**KIRKLEES METROPOLITAN COUNCIL  
INVESTMENT & REGENERATION SERVICE**

**DELEGATED DECISION TO DETERMINE PLANNING APPLICATIONS**

Reference No:	<b>2022/62/90678/E</b>
Site Address:	36, Fir Parade, Ravensthorpe, Dewsbury, WF13 3BH
Description:	Erection of two storey side and rear extensions
Recommending Officer:	Jennifer Booth

**DECISION – CONDITIONAL FULL PERMISSION**

ELEVATIONS

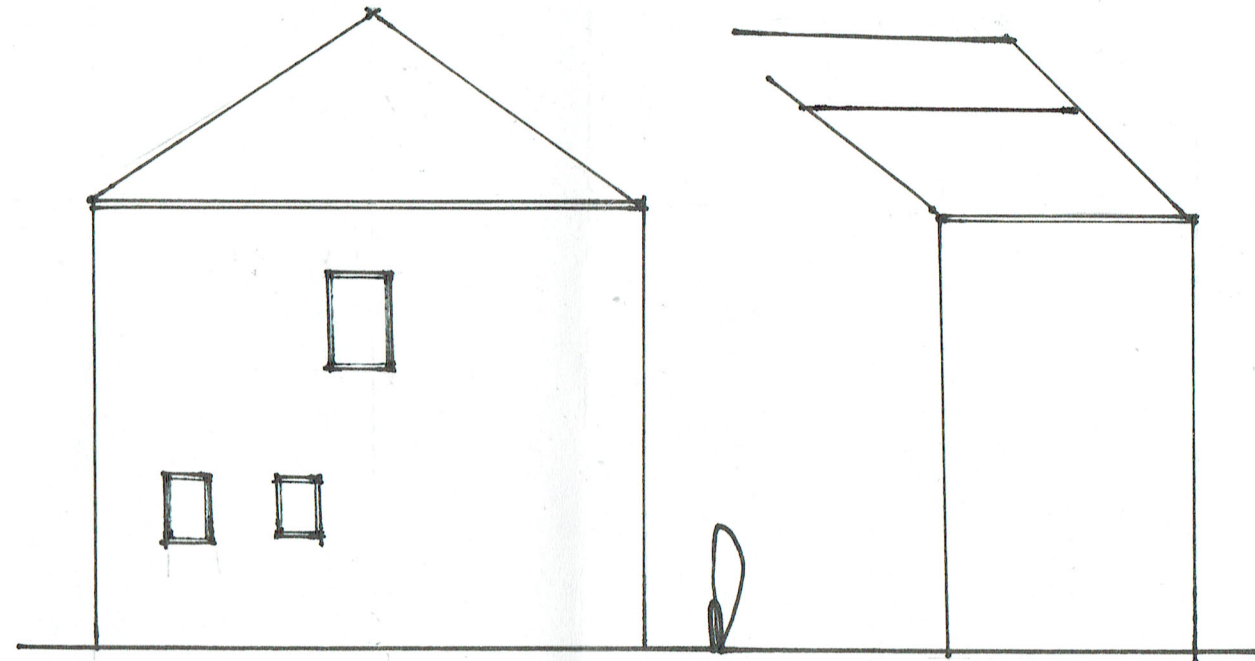
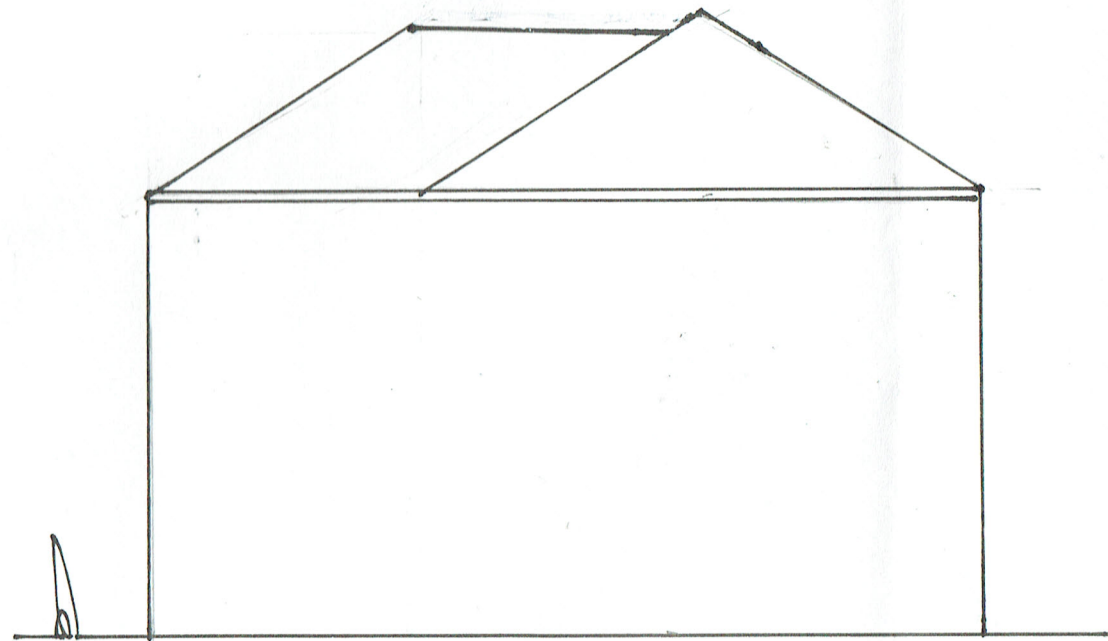
The submitted plans raised concerns in terms of the design and appearance with the side extension and the rear extension. Kirklees Development Management Charter together with the National Planning Policy Framework and the DMPO 2015 encourages negotiation/engagement between Local Planning Authorities and agents/applicants. The agent was offered the opportunity to amend the scheme and provided amended plans which altered the roof form of the rear extension and set the side extension back from the front and down from the roof. As the changes were limited, the amended plans have not been advertised.
